# Preferred Project Report

Application No.MP09-0039 for  
Mixed-Use Retail/Commercial/  
Community/Entertainment/  
Residential Complex

157 Redfern Street  
REDFERN

October 2009

PATH	C:\Documents and Settings\MRichards\My Documents\00 MR LOCAL FILES\DEI00308_DA Model_MR LOCAL_091007.rvt	JOB No.	DEI00308
TITLE	Proposed Shadow Diagrams June 21 (Winter Solstice)	DATE	Feb 2009
		SCALE	@ A1 1 : 100
		DWG No.	DA053 A

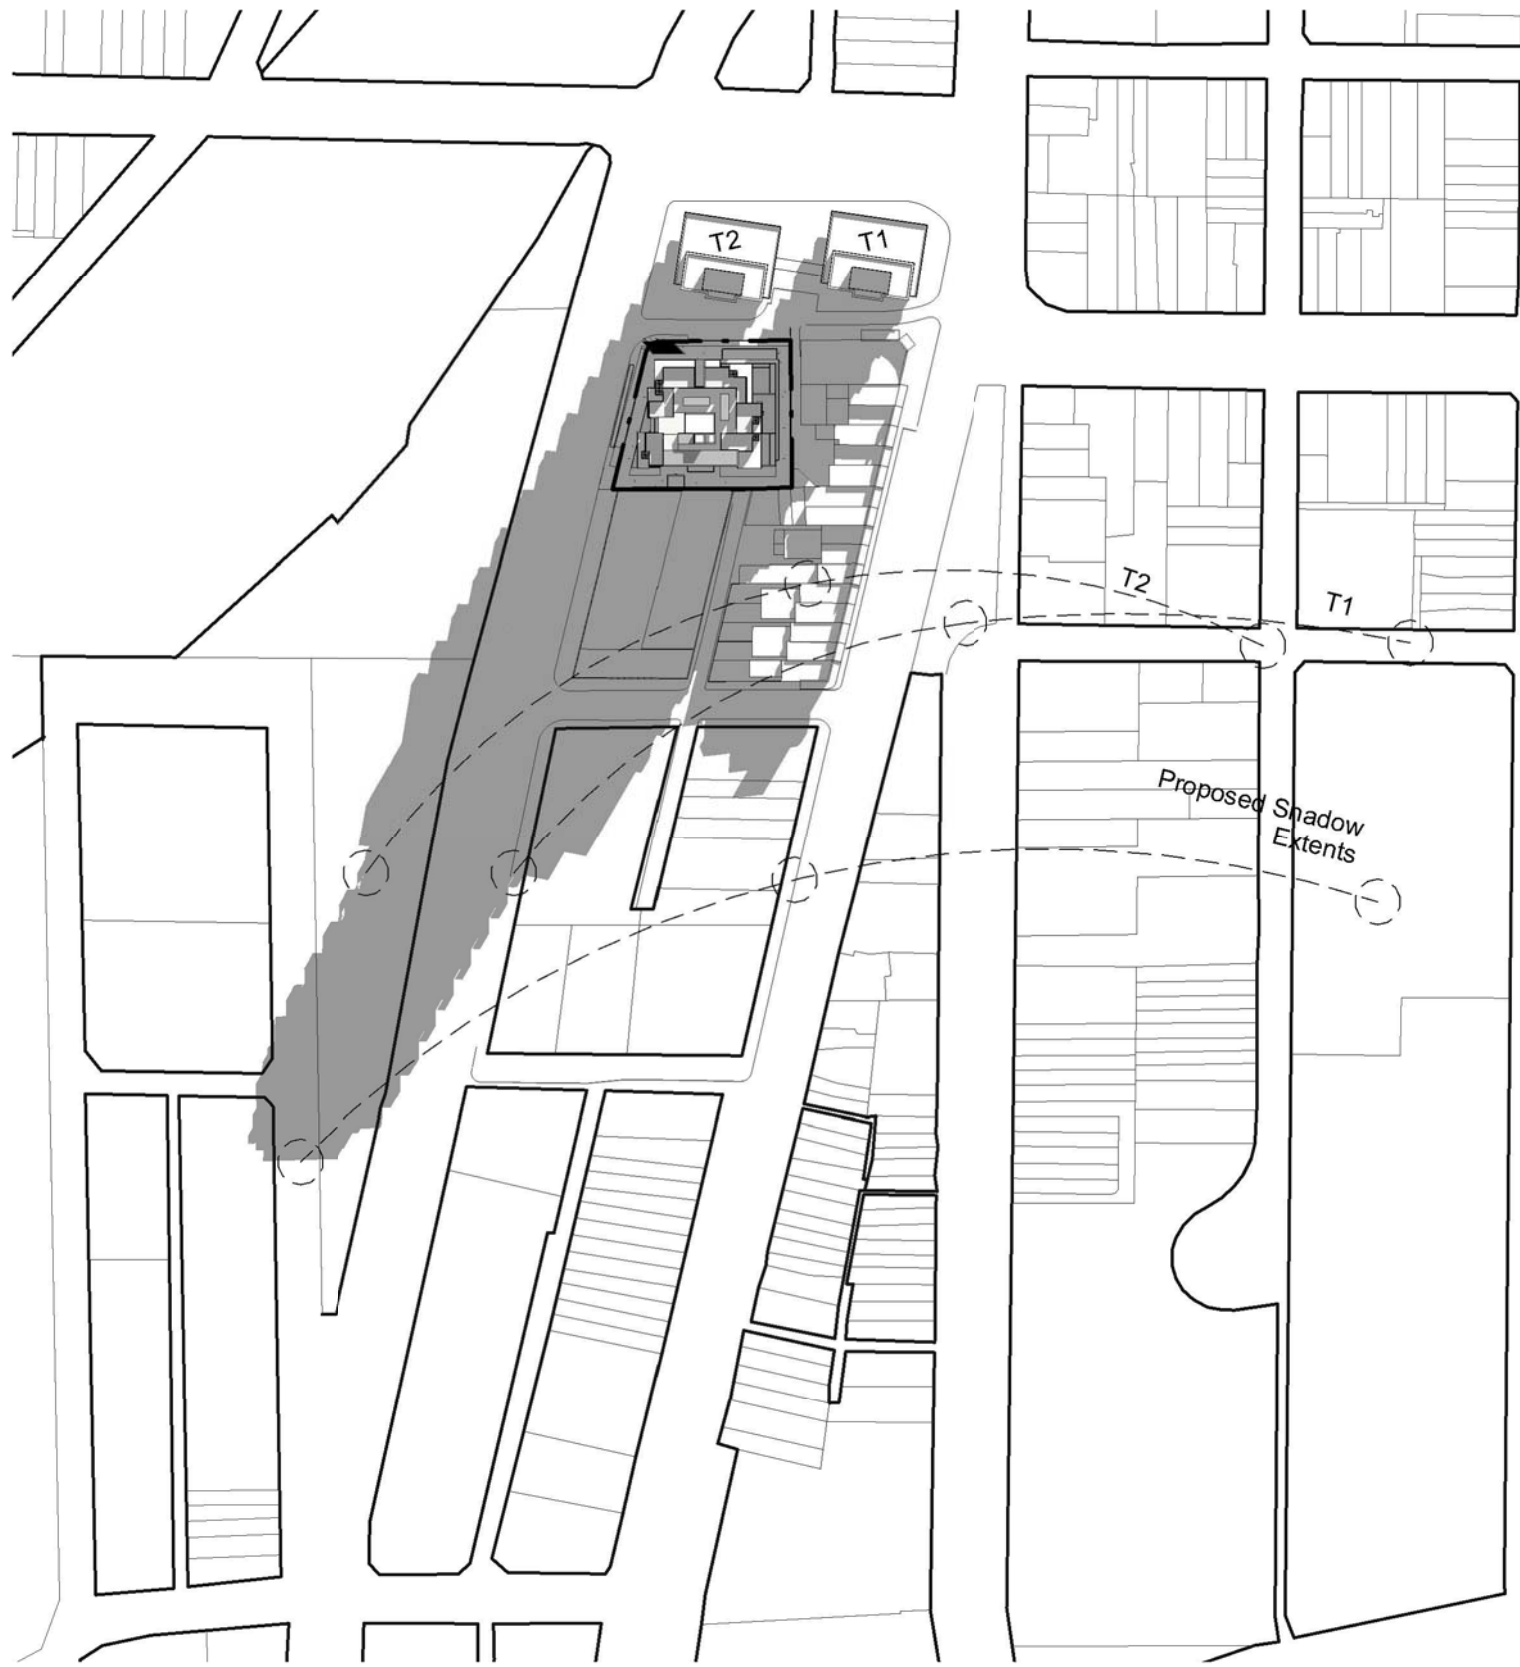
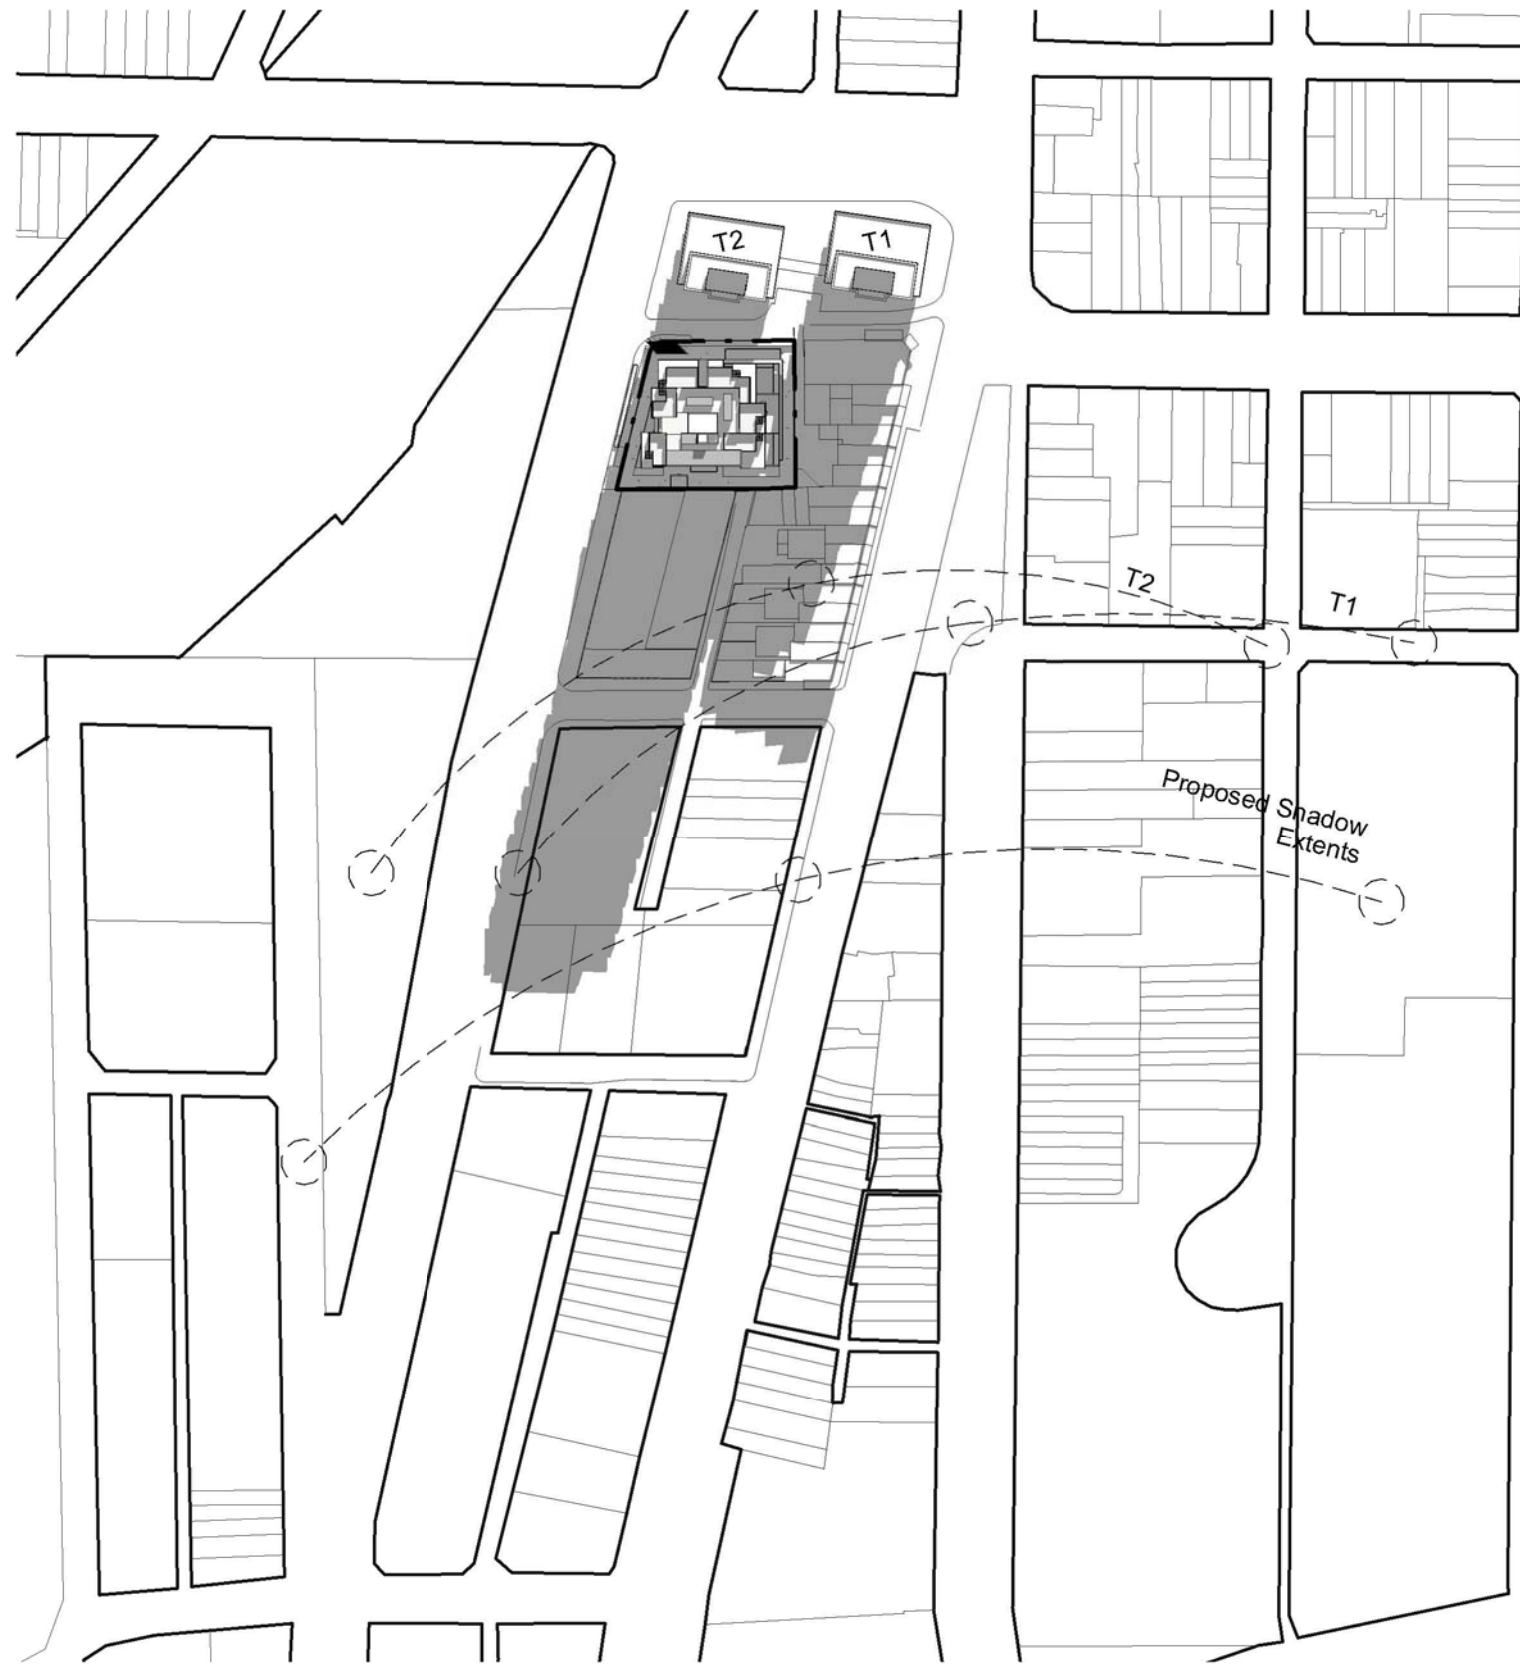
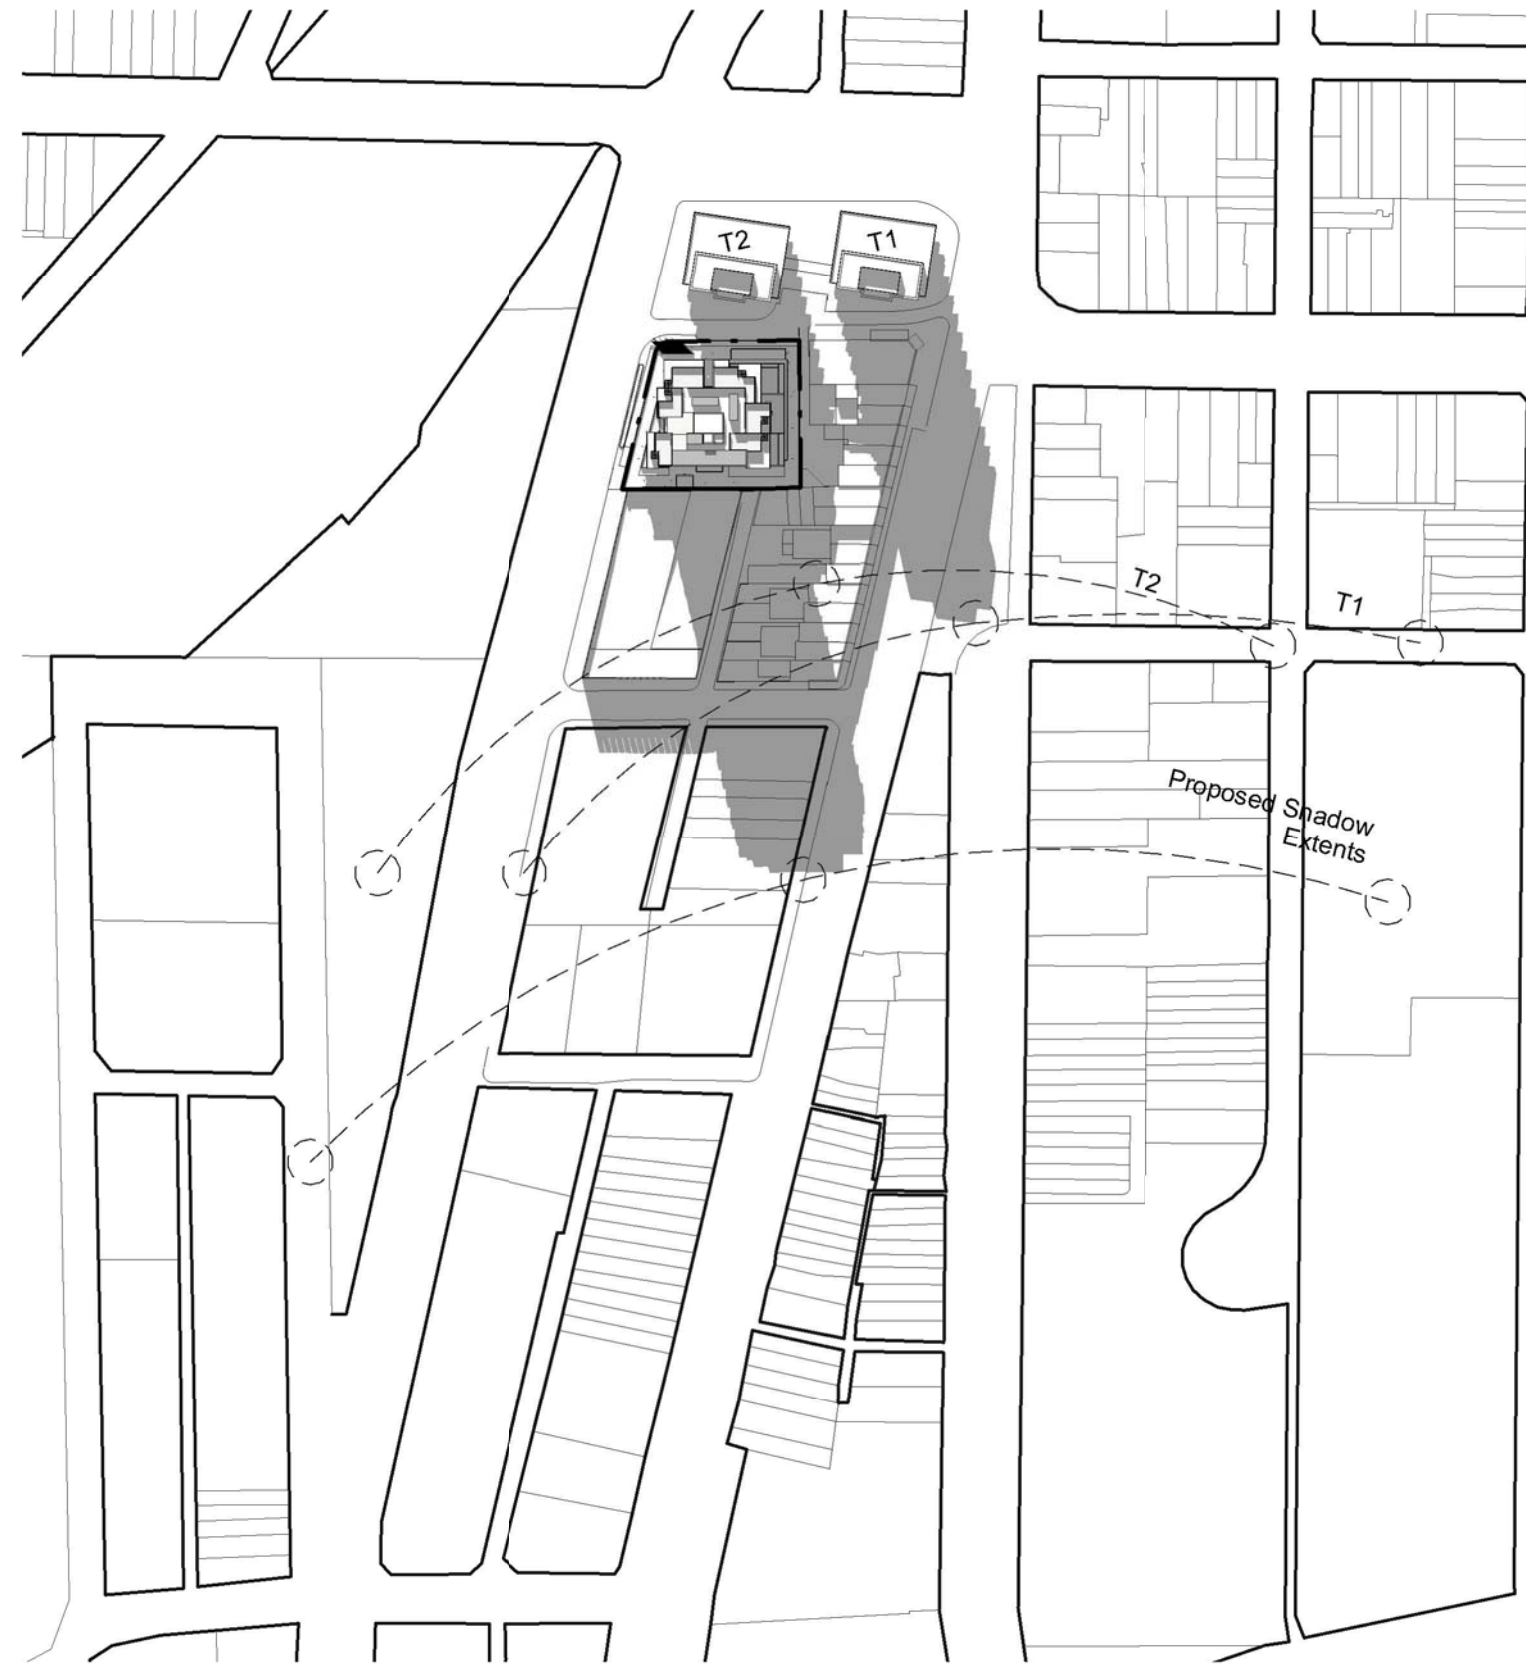
The number of the community submissions raised issues relating to overshadowing, particularly of 13 Margaret Street, while the RWA requested additional shadow diagrams to be submitted for 10am and 2pm.

Shadow diagrams were contained on the plans that were submitted with the application and the additional shadow diagrams requested by the RWA have been included in the preferred project plans contained in **Appendix 1**.

The proposal will marginally overshadow 13 Margaret Street between 9.30am and 10.30am at the winter solstice.

The re-positioning of the building as shown on the preferred project plans contained in **Appendix 1** will, to a minor extent, ameliorate shadows cast to the south and south-east.
